Application Reference:- M/123/17/HH

**Two storey extension to existing building -
REVISED PLANS**

**Little Thatch, 93 Middleton Road, Middleton on
Sea PO22 6DW**

REVISED EAST ELEVATION.

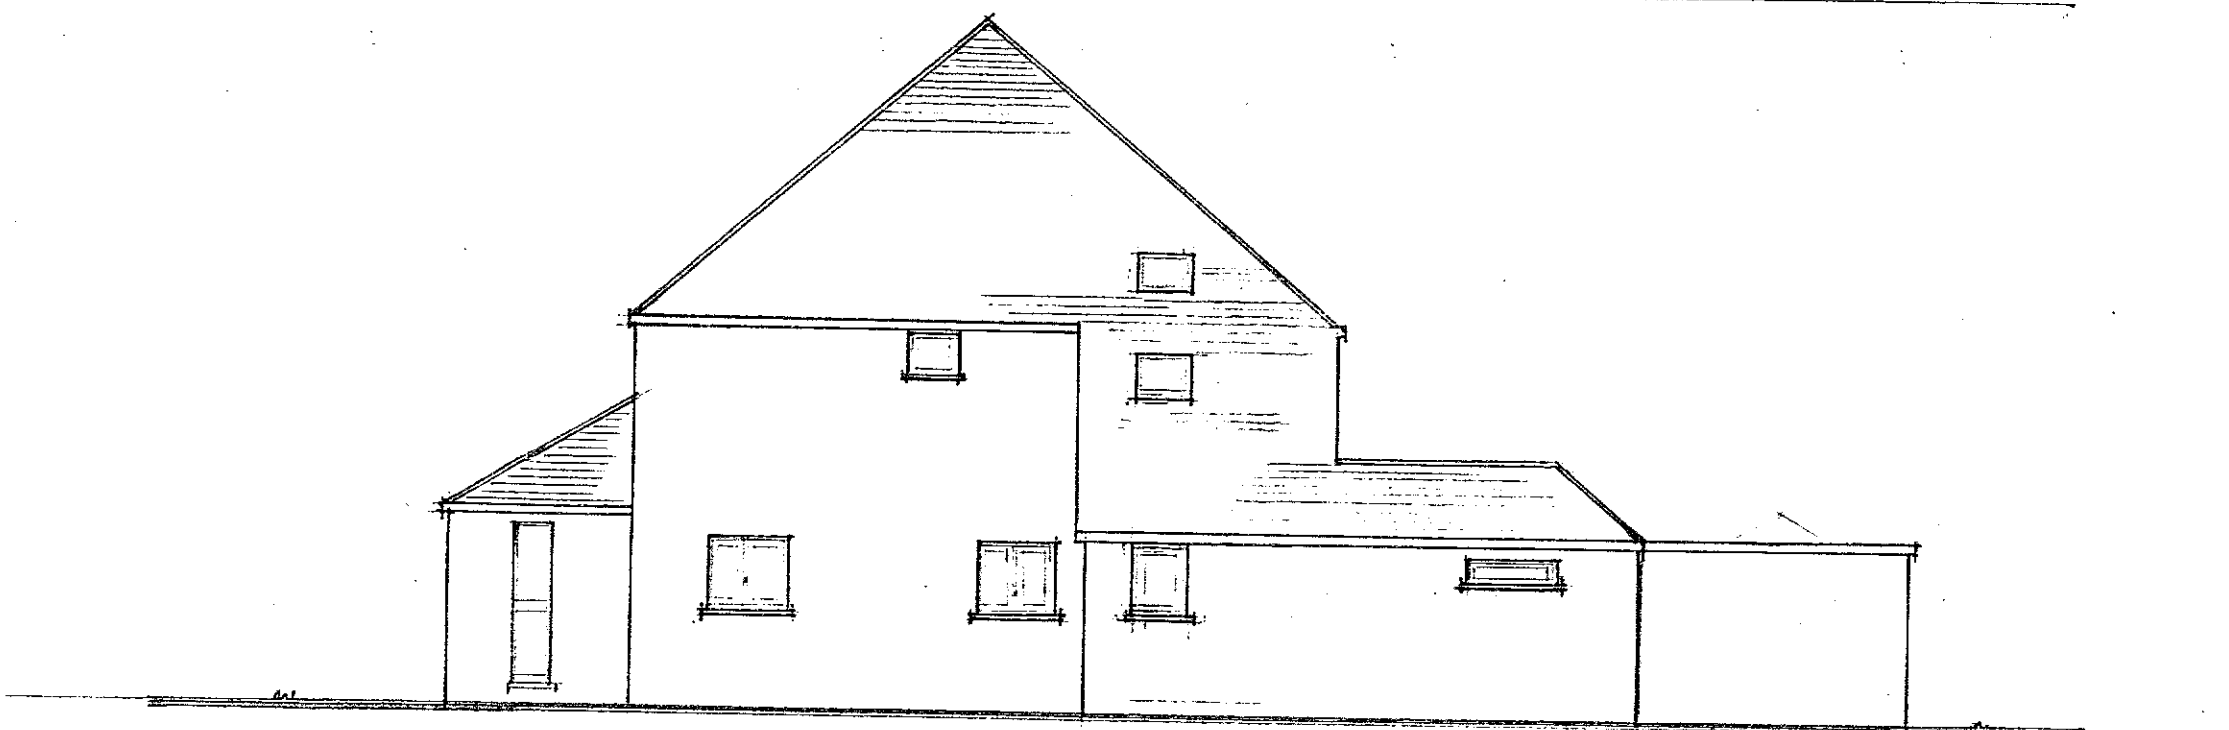
The lowering of the ridge next to us is rather 'token' in nature and, as shown on the comparison drawing (no. AB:100 12), it would still be much higher than the existing thatched roof. It is not possible to say how much lower the roof on the east elevation would be or whether the main part of the house is now substantially larger than before appearing to make it lower. The substantial increase in the height would be particularly dominating from our point of view but the overall bulk of the roof would be prominent from various angles. The size of the new front dormer (with wide front cheeks) and the over-reliance on rooflights on the rear elevation, in particular, emphasises its scale. A more subservient annexe would help minimise the impact on the eastern side.

These revised plans add additional bulk at the front of the dwelling, more or less in line with the rooflights over our kitchen diner and the dormers above. This element raises a new issue for us and the east elevation on the comparison drawing helps to highlight the extra massing when viewed from our property.

It isn't clear how far the east elevation will be

extended on its south side. The measurements are unclear. Currently there is a large flat roof glass extension to the lounge similar to a conservatory. If this is now to be incorporated in the southern roof line then the drawings are not to scale as this flat roof extends roughly 2m and is not shown on the dotted line on AB-100-12 V5.

EAST ELEVATION

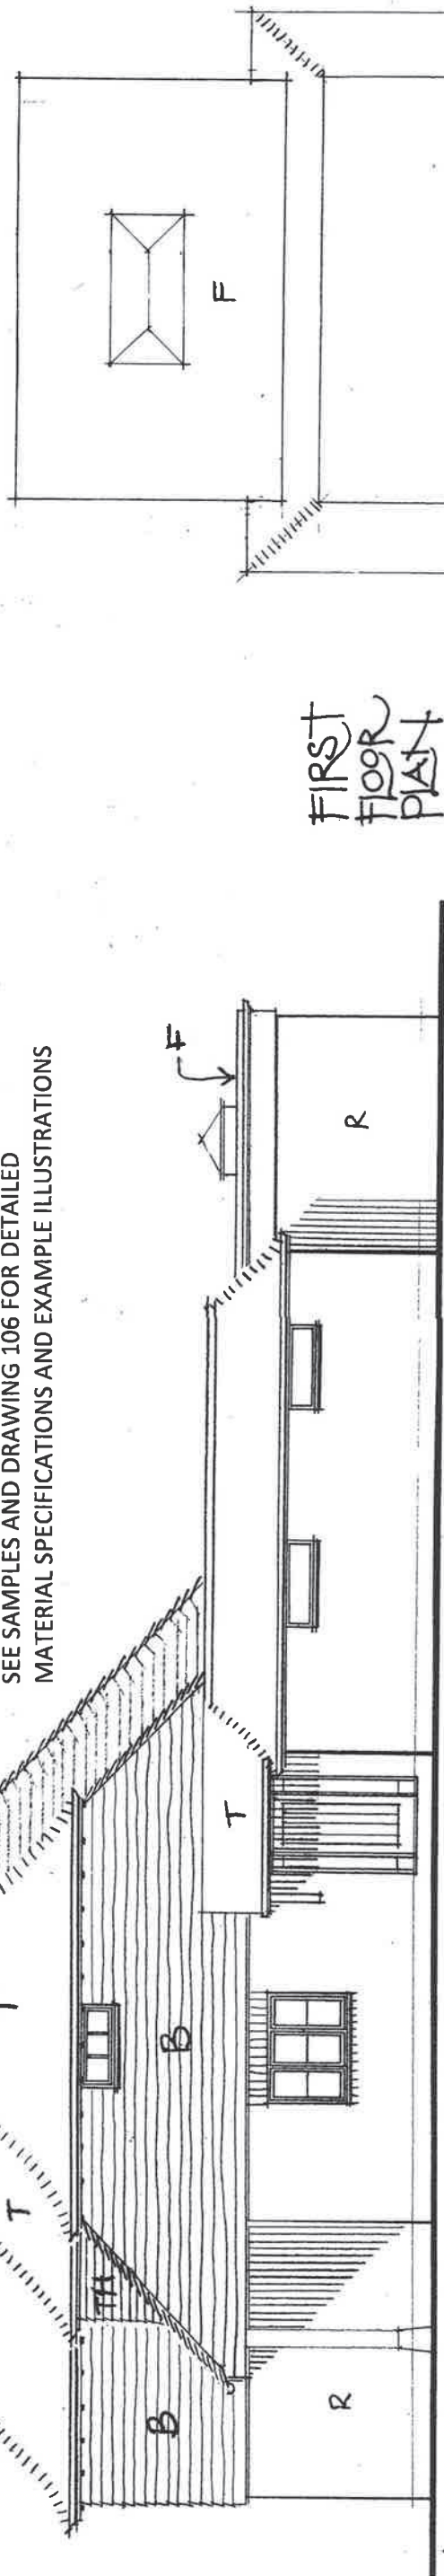
Raised / ramped second front door on the east elevation in very close proximity to our habitable rooms and external sitting out area.

Due to the proposed arrangement we don't consider this door to be a 'rear entrance' as annotated. It

would be well-used by the occupiers of the annexe / self-contained unit and would be the equivalent of a 'front door' with all its associated footfall, activity and lighting etc. Its relocation to a different elevation does not 'move the rear entrance door further from the east boundary' (email Mr Wilson to Planners 8/2/18) and raises new issues for us - the ramp shown on the plans increases its overall height and the direction of the lighting is likely to be more disturbing.

Suggested alternative option - There are seven other doors (six patio in nature) shown on the revised plans. This includes one on the front elevation of the annexe. We would question why the latter could not be used to access the annexe. This would be further away from the boundary and our patio, as well as being on an elevation which does not directly face our property.

Of particular concern - we would also like to point out that the location of this upper level window on the first floor plan does not tie up with the location shown on the east elevation drawing. The distance between the window in the dormer and the southern frame of the high level window do not seem to correspond.

FIRST  
FLOOR  
PLAN

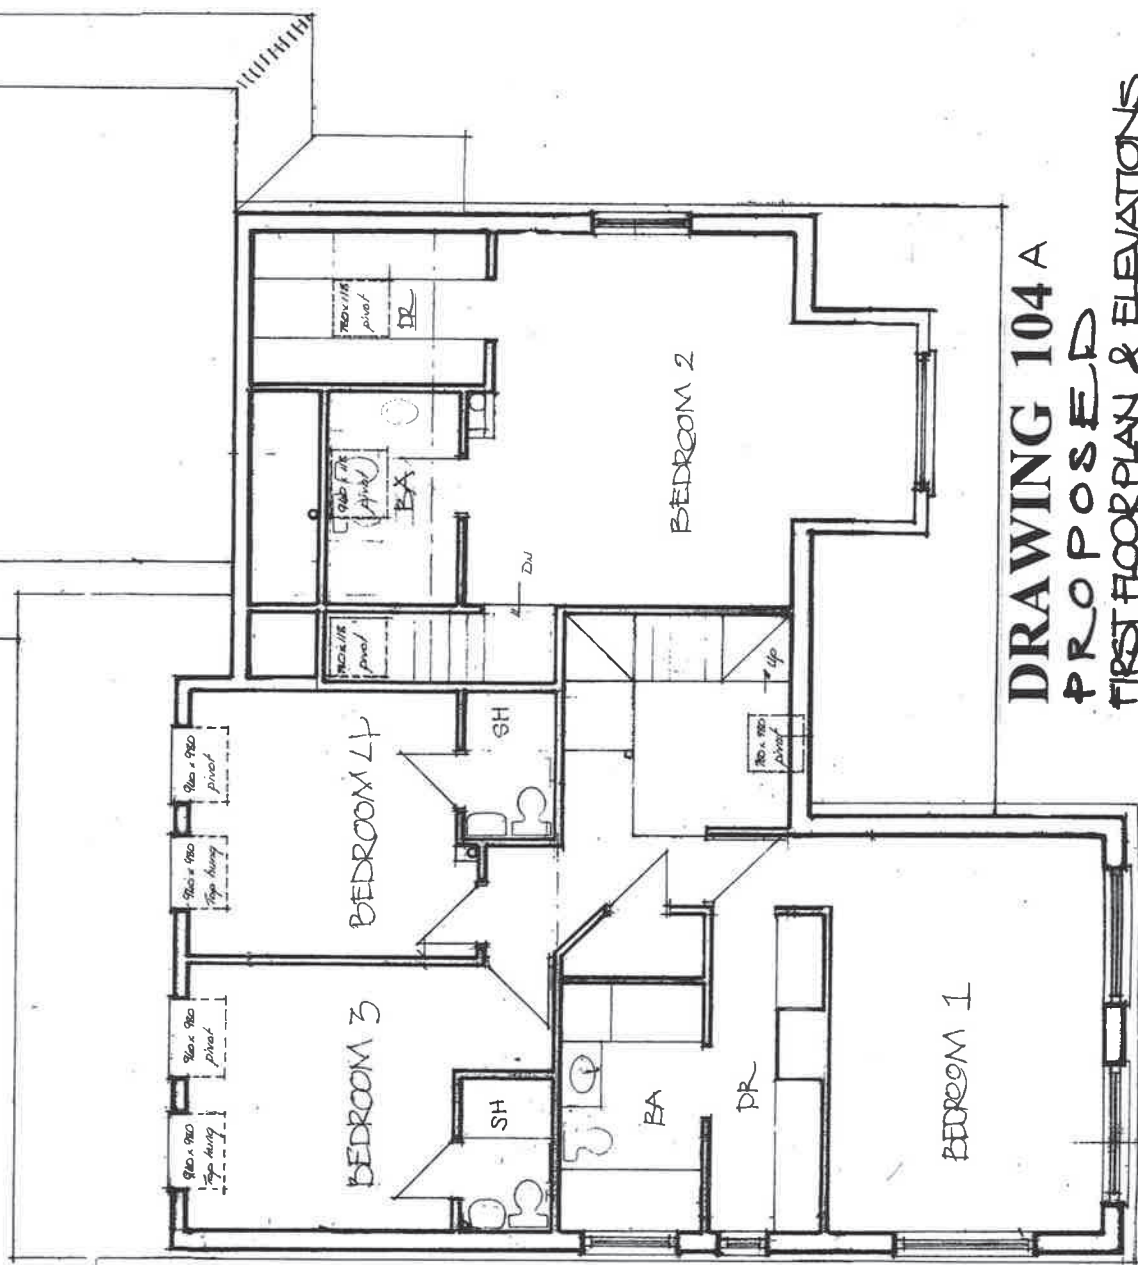
Currently there are only ground floor windows facing us at no. 93, hidden behind the fence. The removal of the two side rooflights is welcomed but we remain concerned about the upper floor window. This would serve the bedroom in the annexe (which is not at all connected with the other bedrooms or first floor).

Whilst it is high level, its installation 1.7m from the finished floor level would still allow certain people, depending on their height, to look out of it towards our sitting out area and our kitchen diner (with rooflights) and dormers above - these all face no. 93 and are within close proximity of the boundary. 1.7m is

Suggested alternative option - As the annexe bedroom would have a three-paned dormer window on the front elevation - facing south- we would argue that the proposed side window could easily be deleted without any detriment to the occupier.

BLOCK PLAN 1:500

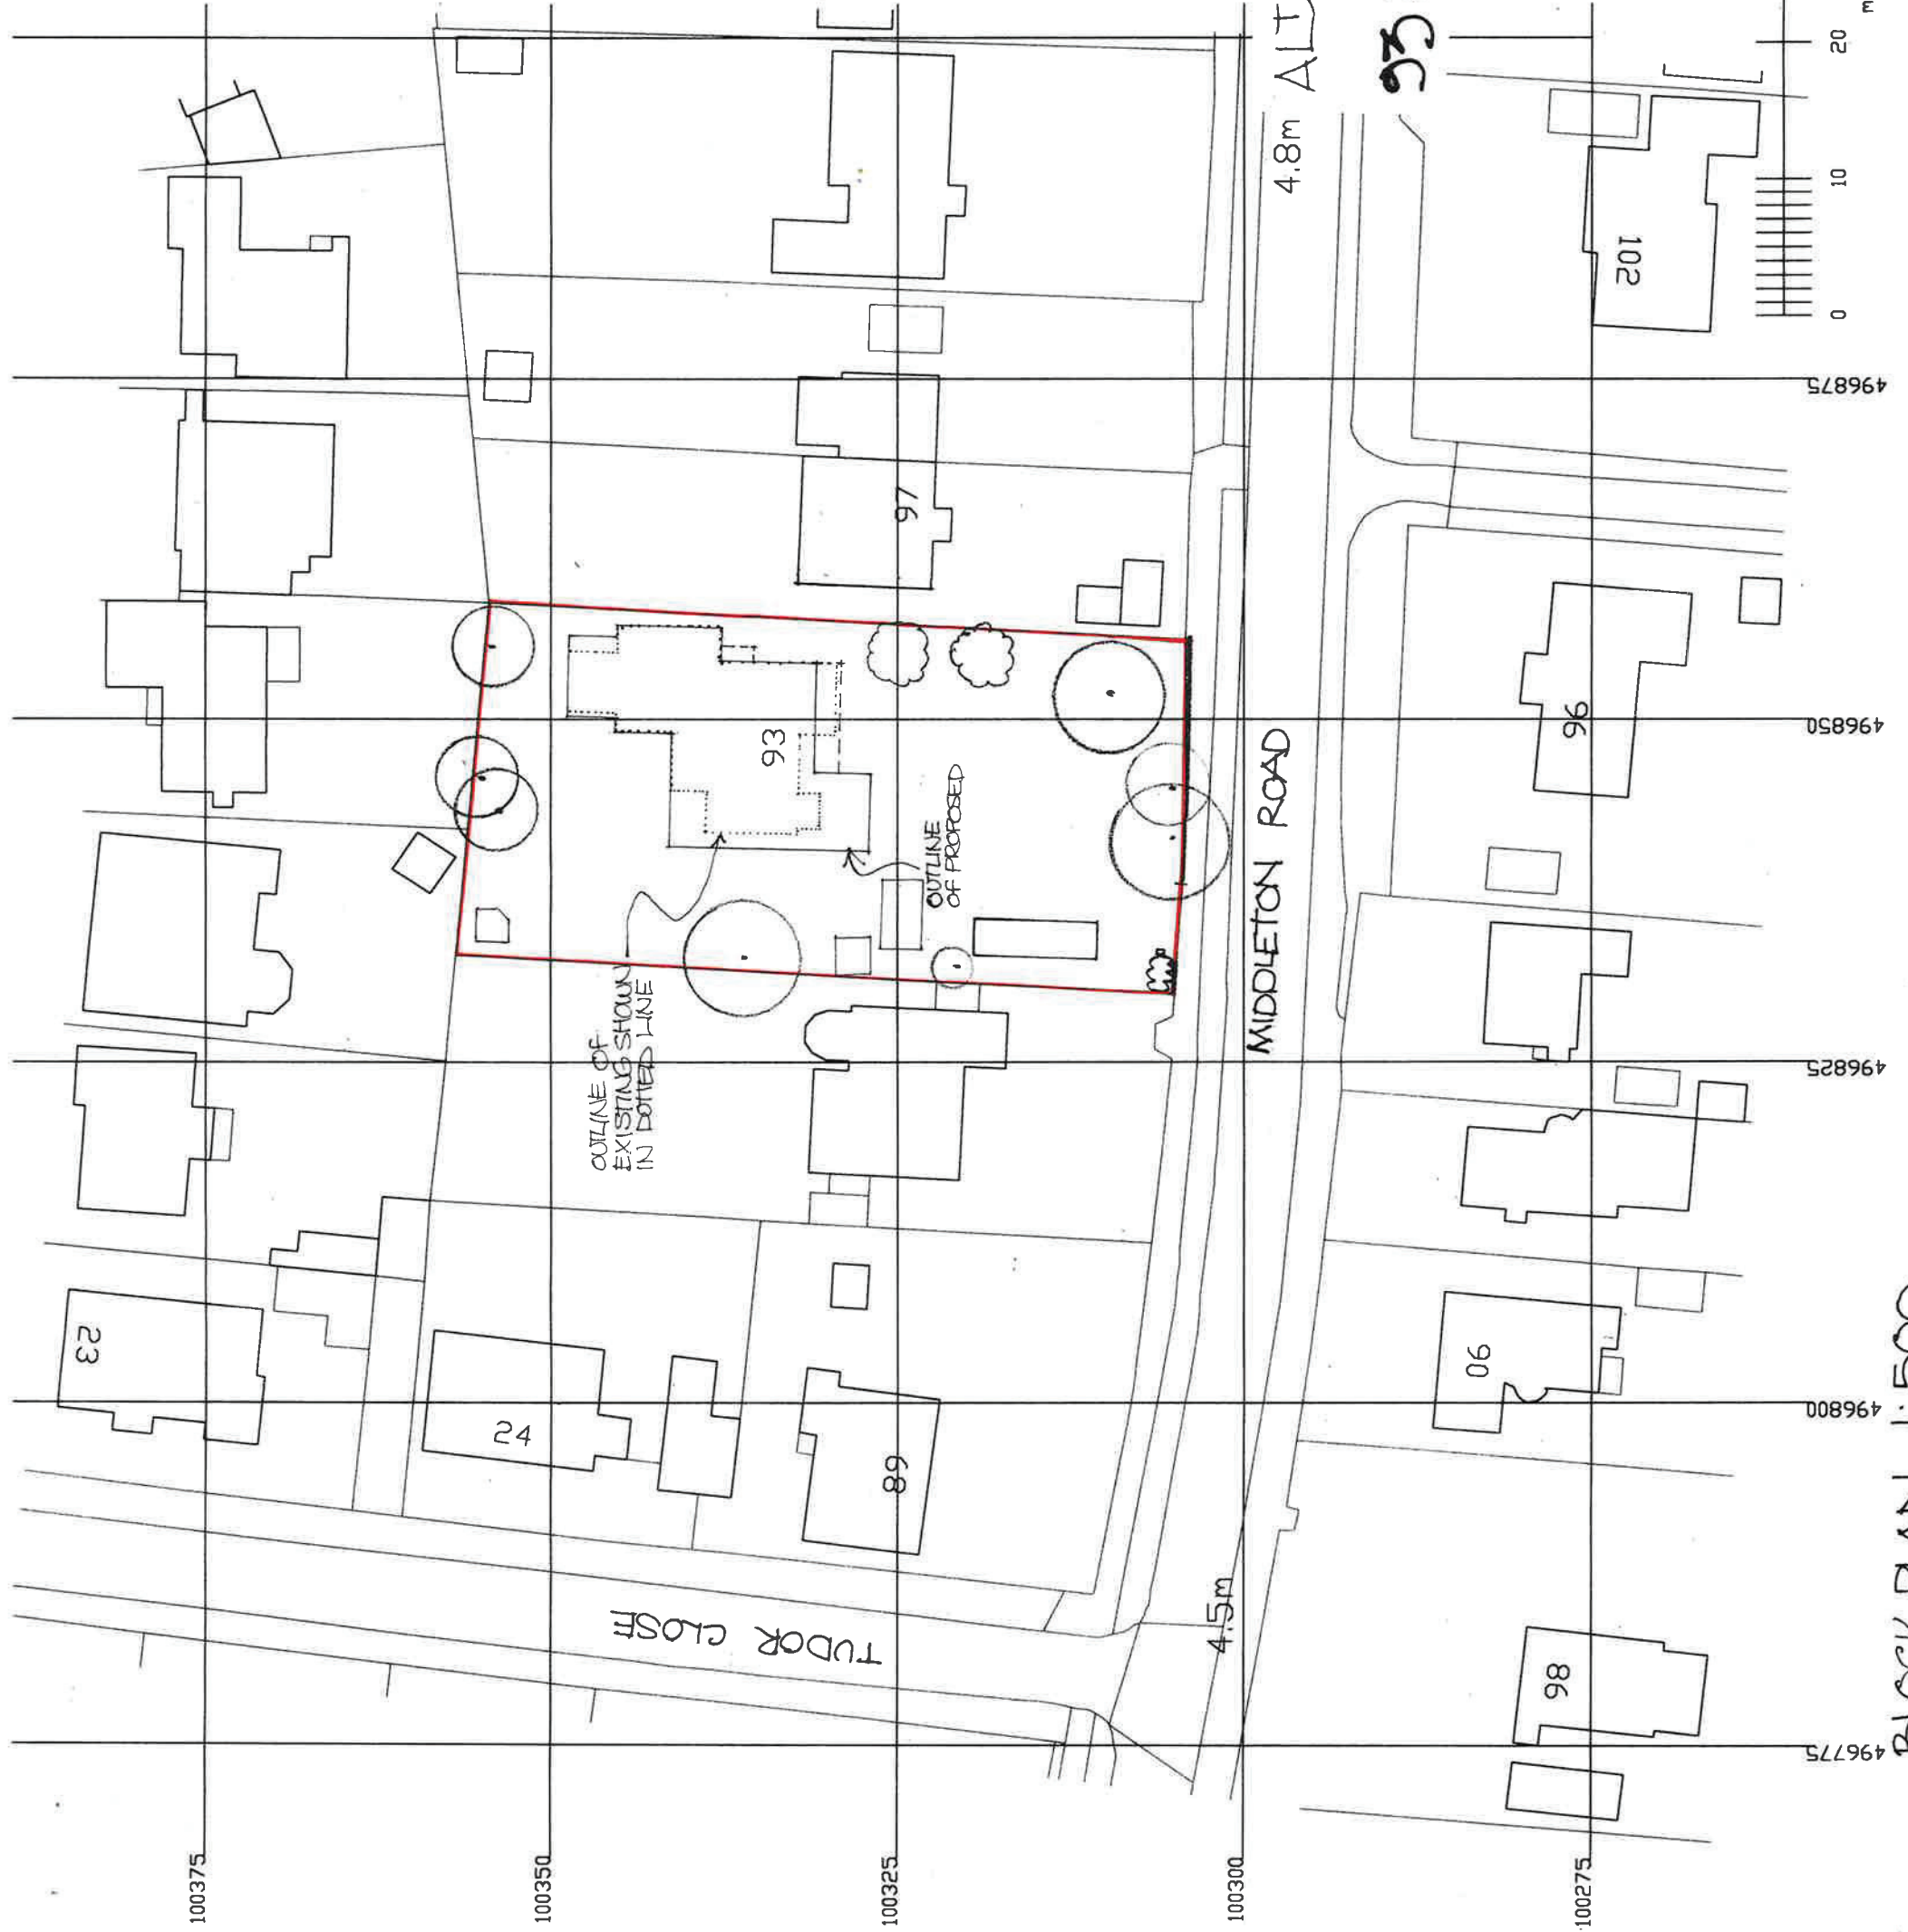
We also still have concerns about the presentation and accuracy of the plans. Furthermore, our property has not been included in the 1:500 Block Plan. The Location Plan is incorrect. Our house is not drawn to scale and is much closer to the boundary in reality.

We feel that the current and proposed relationship with our house needs to be included in the revised set of plans. The various distances to the mutual boundary are not the only issues that need to be assessed and they cannot be looked at in isolation. We question the 1m gap annotated on the plan. The block plan also shows the boundary to

house gap as 3.3m. Whereas AB-100-7 V5 – ‘proposed floor plan and elevation’ shows this distance to be 3.4m. We would therefore like to request please that key boundary measurements are double-checked on site.
